**PRIVATE DETENTION BASIN /  
STORMWATER QUALITY BEST MANAGEMENT PRACTICE  
MAINTENANCE AGREEMENT AND EASEMENT**

B. WHEREAS, Developer desires to develop on the Property an industrial use to be known as **Claremont Business Park 1A-Lot 2 – Filing No. 1**; and

FINAL PLAT
CLAREMONT BUSINESS PARK
1A-LOT 2, FIL. NO. 1
DOB NO. 14-054
DATE PREPARED: 11/08/2019
DATE REVISED:

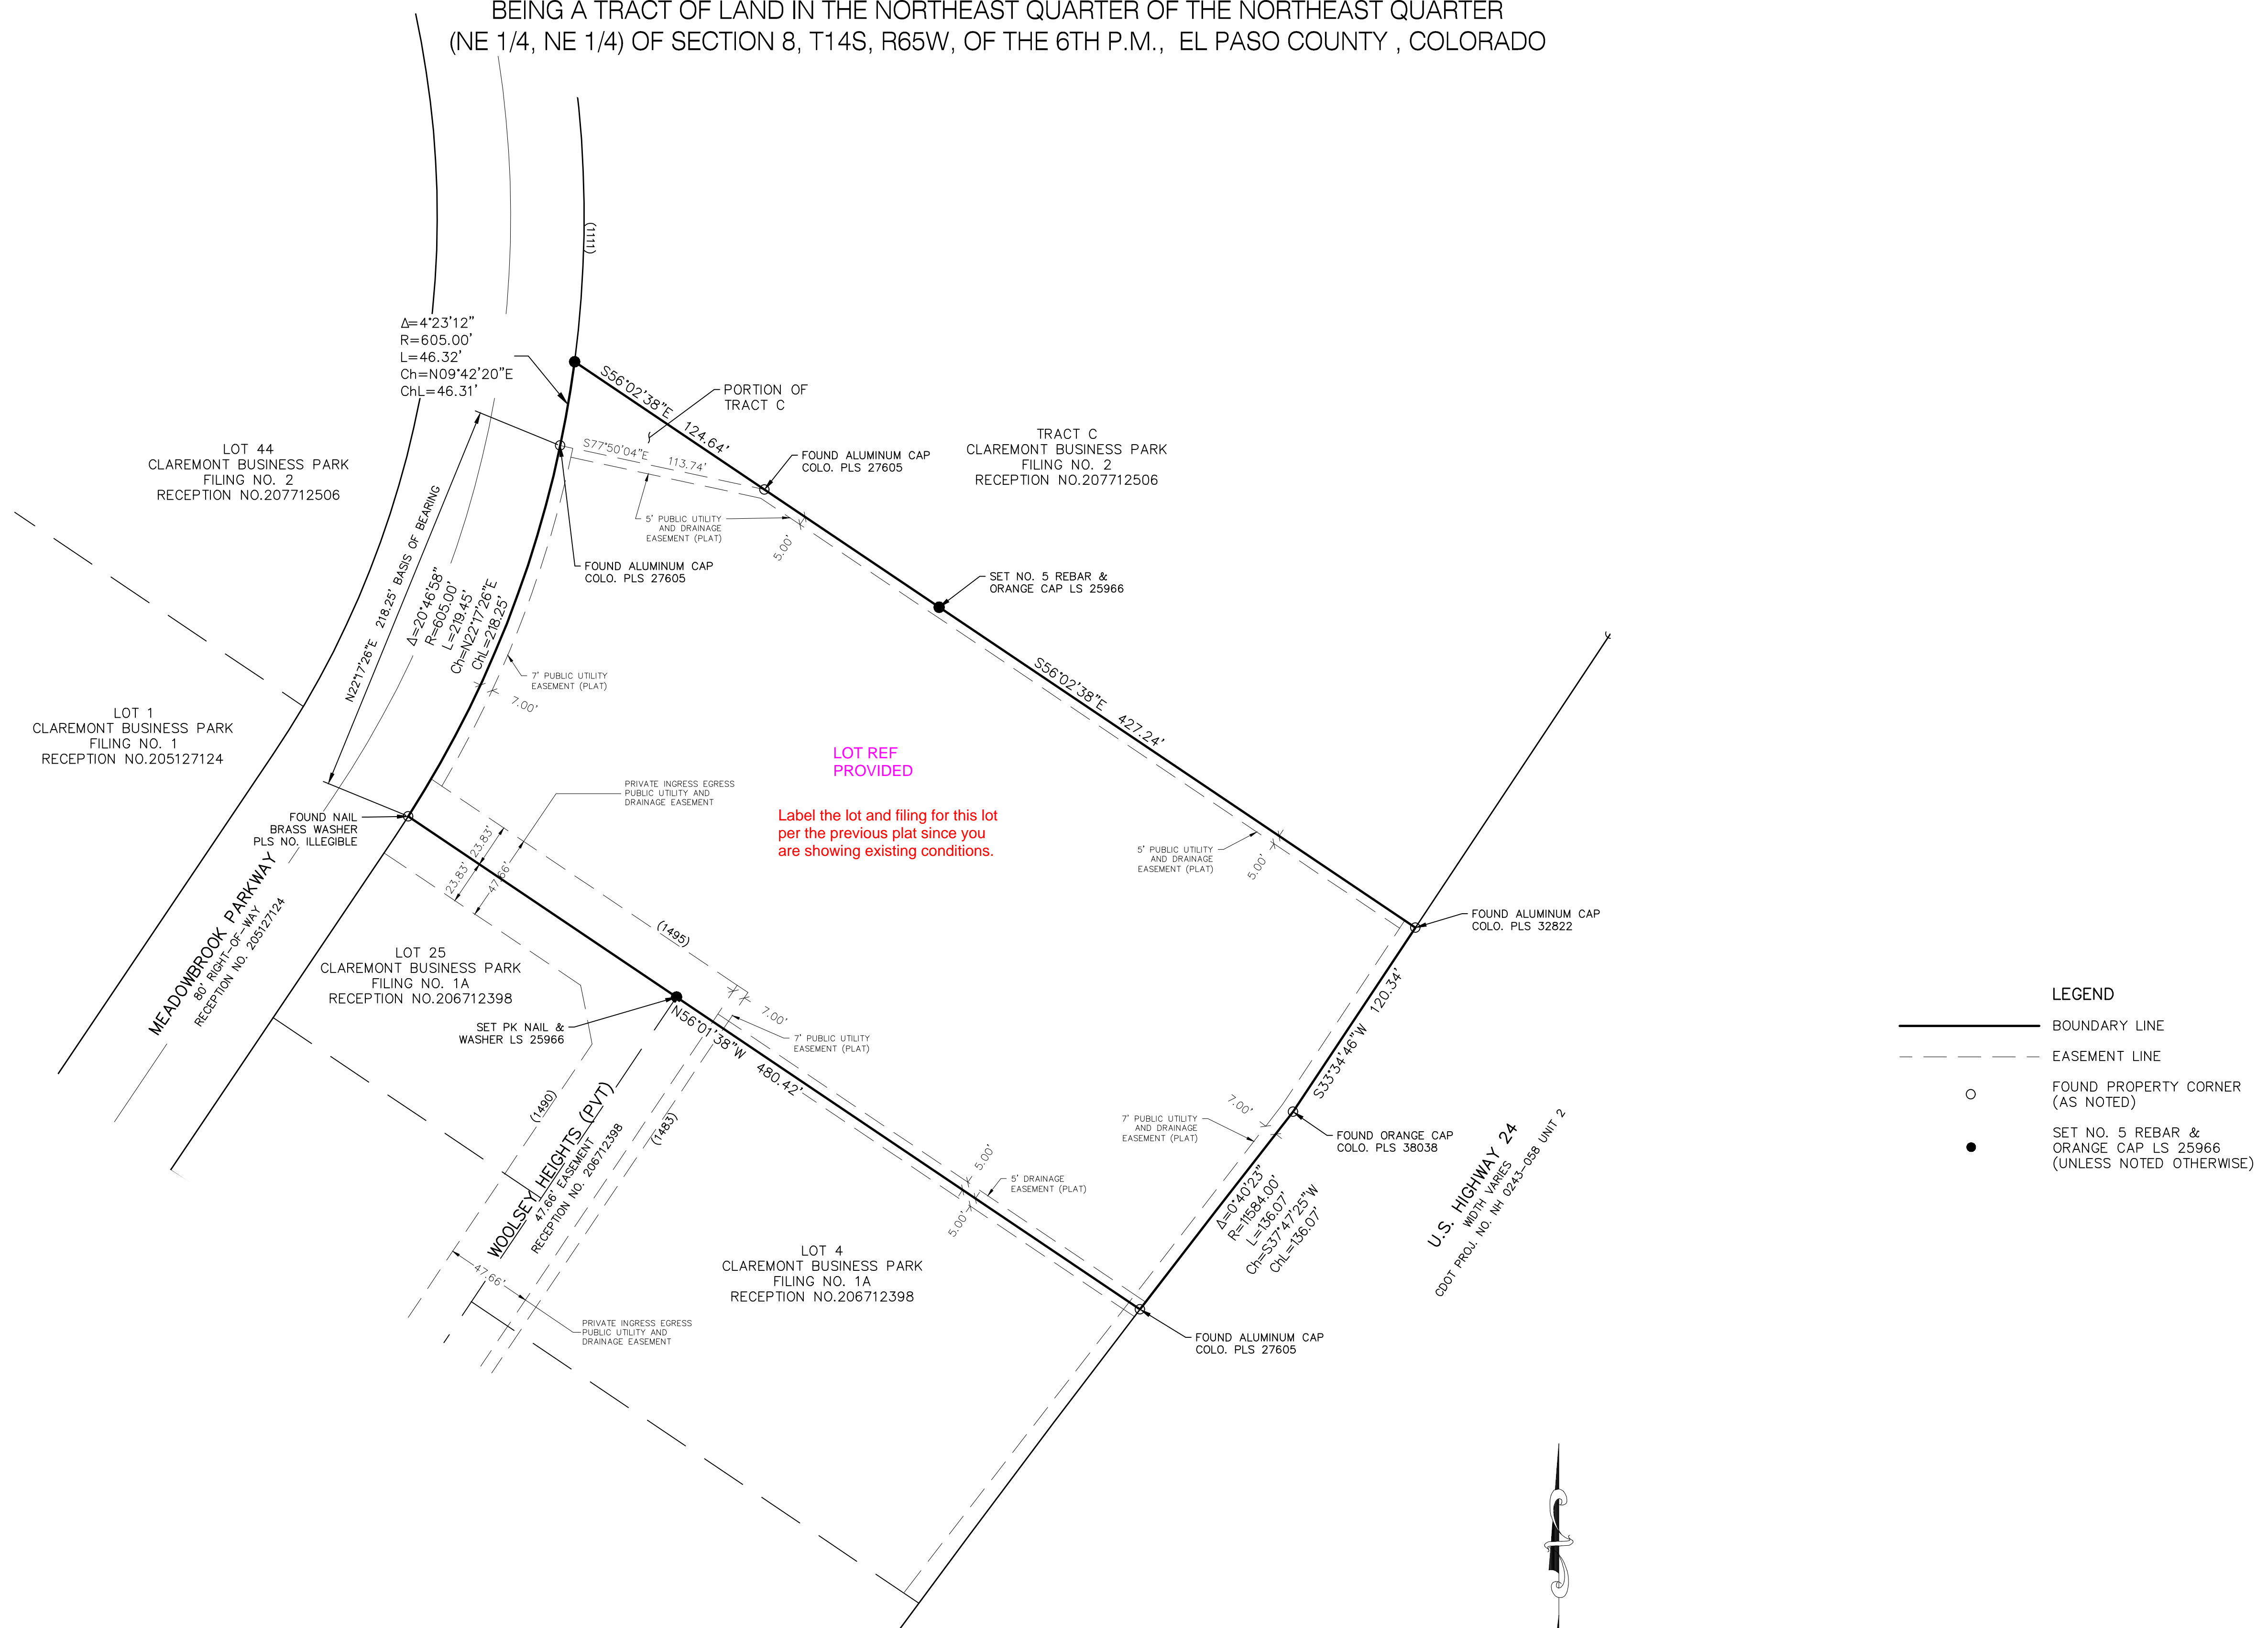
**Commented [LS1]:** Exhibit A must be a legal description of the property subject to the vacation and replat. The drawing attached hereto will be Exhibit B.

Exhibit A has been prepared and included with this submittal
